16th January 2020

Town & Country Planning Act 1990 (as amended)
Town & Country Planning (Development Management Procedure) (England) Order 2015
Application for Planning Permission for Works or Extension to a Dwelling

Development Rear Single storey dining and kitchen extension to match existing character of bungalow
Location 65 Carlton Avenue Aldwick

1
01 Proposed site Plan
1:500

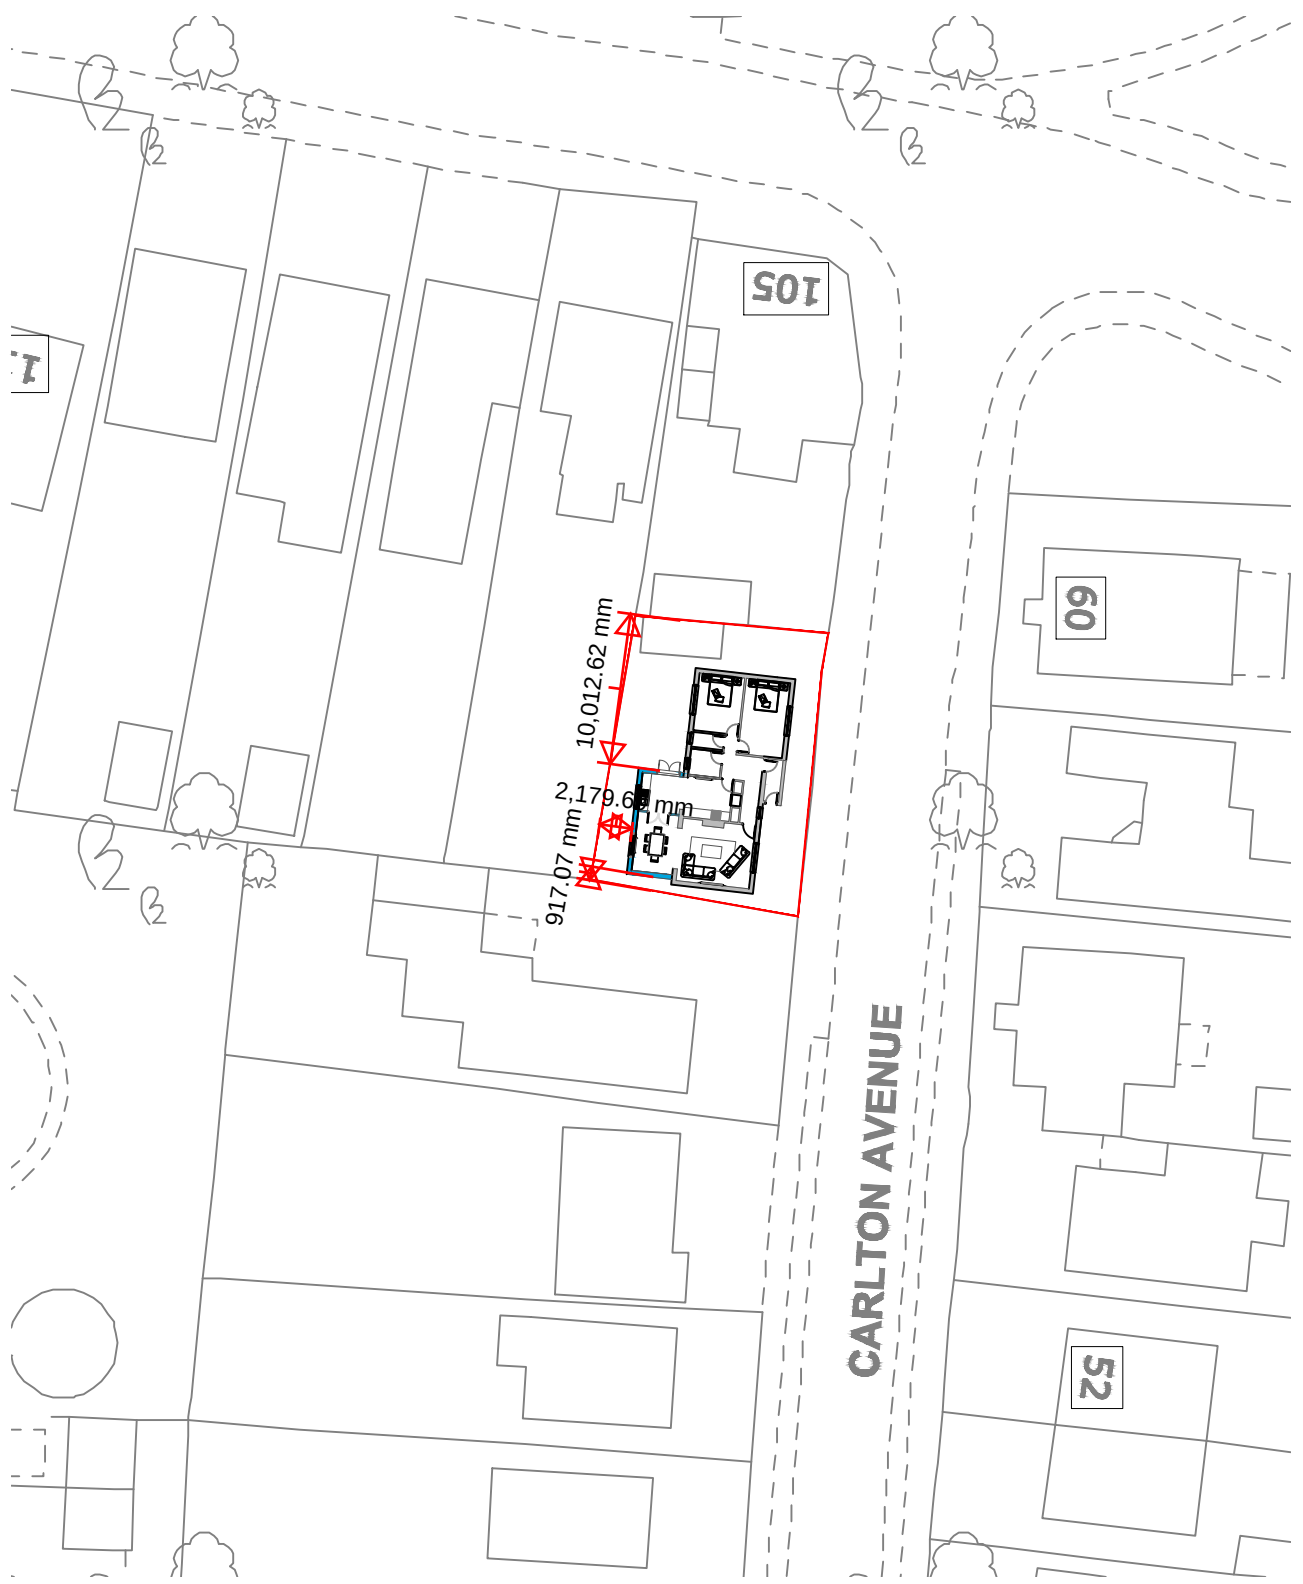
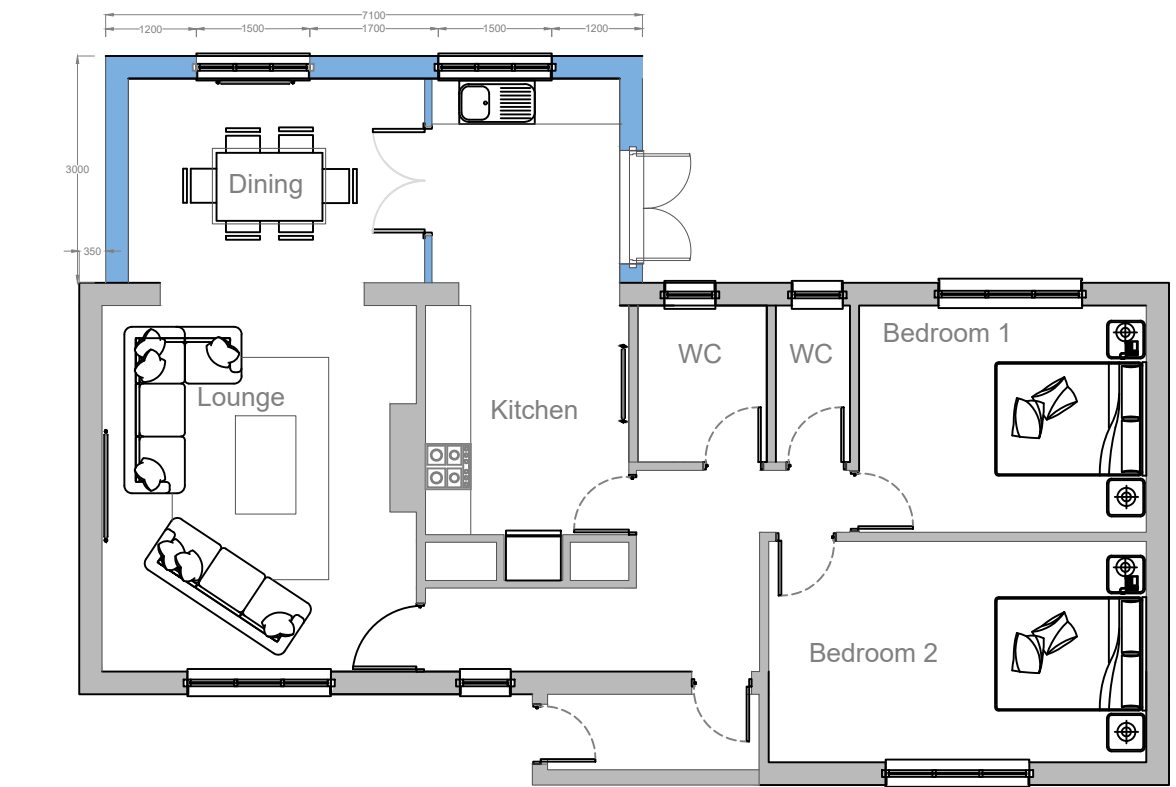
Block Plan: Please submit a block plan which includes dimensions from the proposed extension to all site boundaries.
